Toby Philp - Fwd: Glen Innes Wind Farm (MP07_0036 Mod 2)

Glen Innes Wind Farm (MP07_0036 Mod 2)
Proposed Modification

Comment by Crown Lands

APPENDIX 2 PROJECT LAYOUT

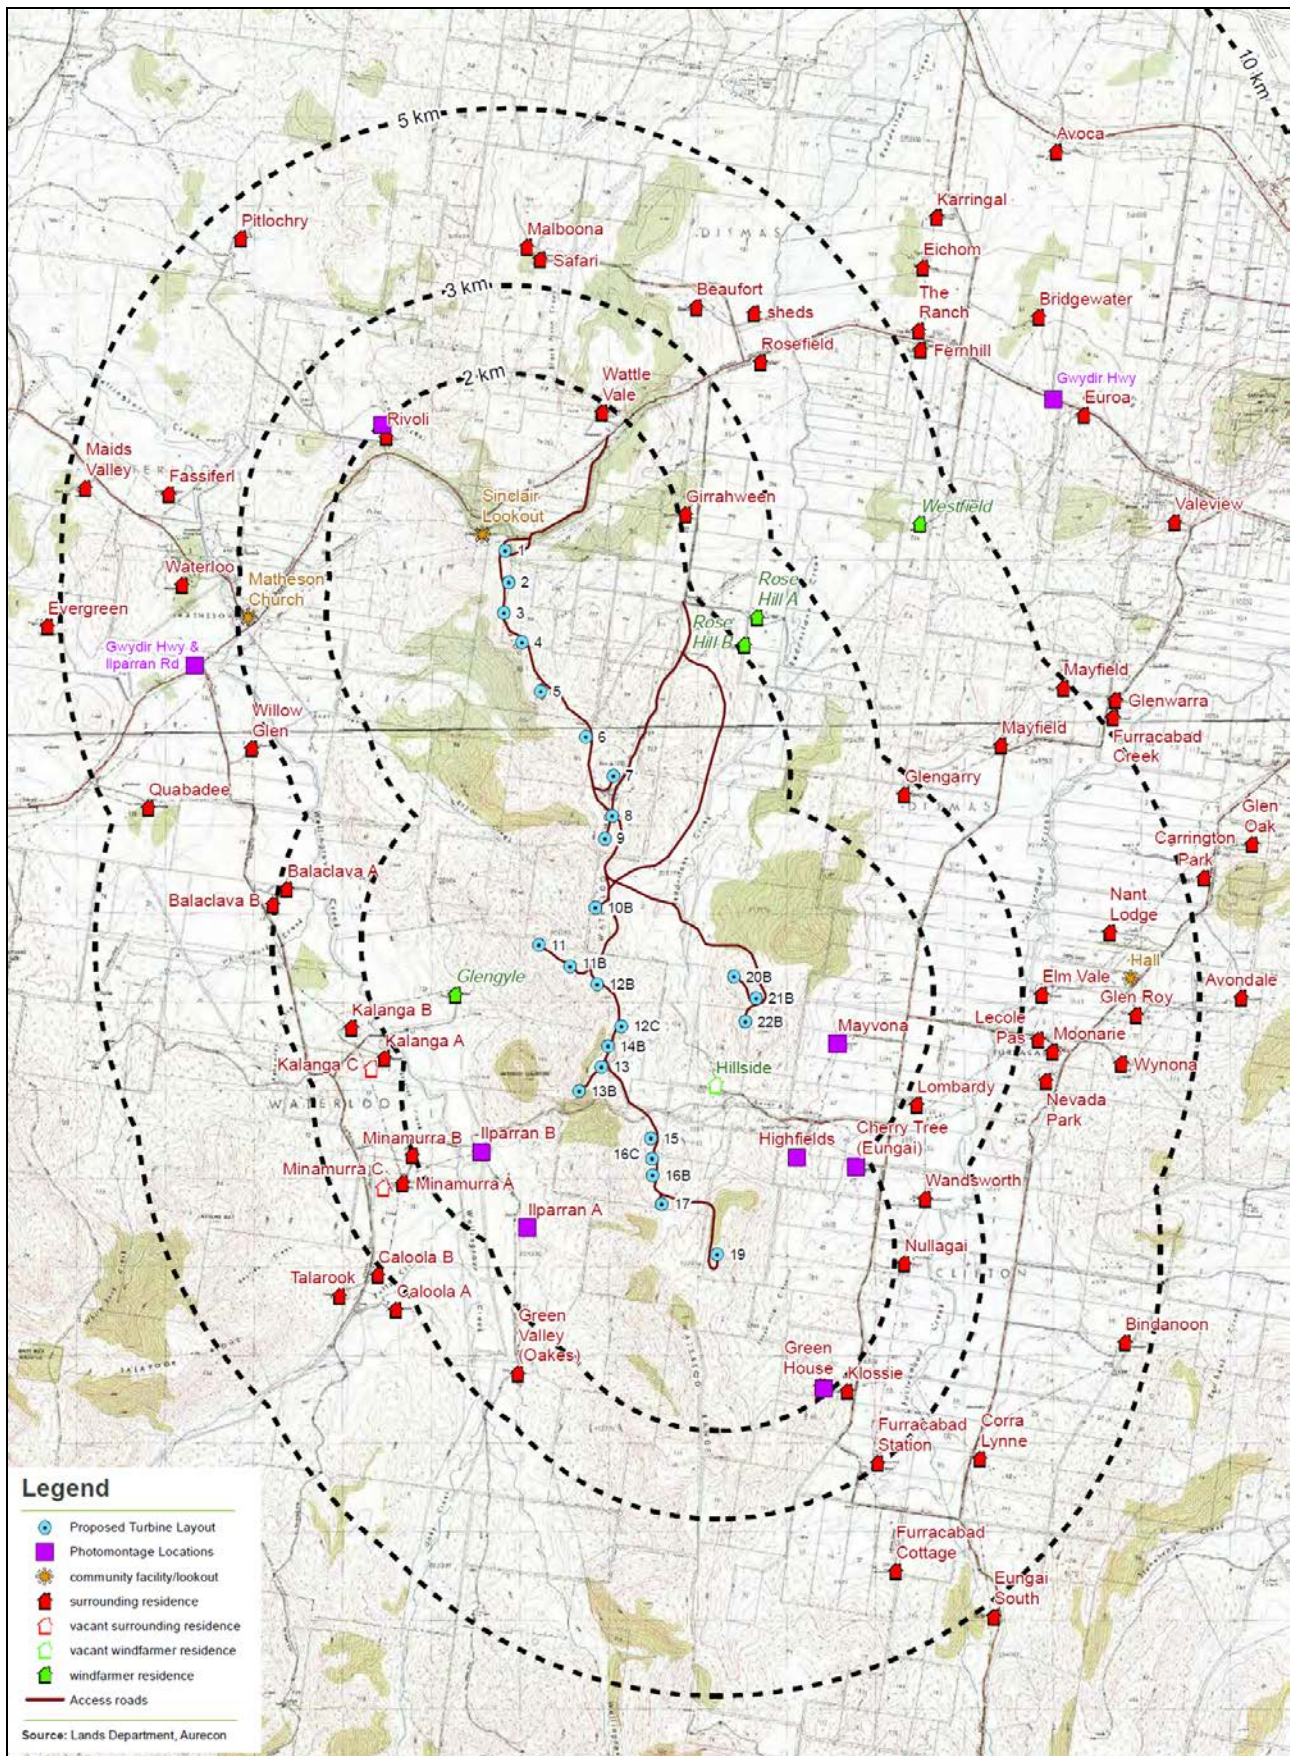
The proposed modifications relate largely to changes in the size of the turbines, and hence an increase in tower height (80m to 89m) and diameter of the blade rotation (100m to 122m). To accommodate these changes, two towers (out of a total of 25) are to be moved from their previous approved locations, namely tower 13 moving 43m NE and tower 13B moving 44m SW).

The relocation of these two towers does not appear to impact on any Crown lands, however the relocation of tower 13 combined with an increase in blade size, and increased blade size of tower 14B brings their reach very close (if not right up to) a crown road. At the northern end of the proposed wind farm, the increase in blade diameter may put the blades over a section of untenured crown road.

Crown Lands advise that the proposed changes will require clarification from the proponent regarding any impact to these Crown roads.
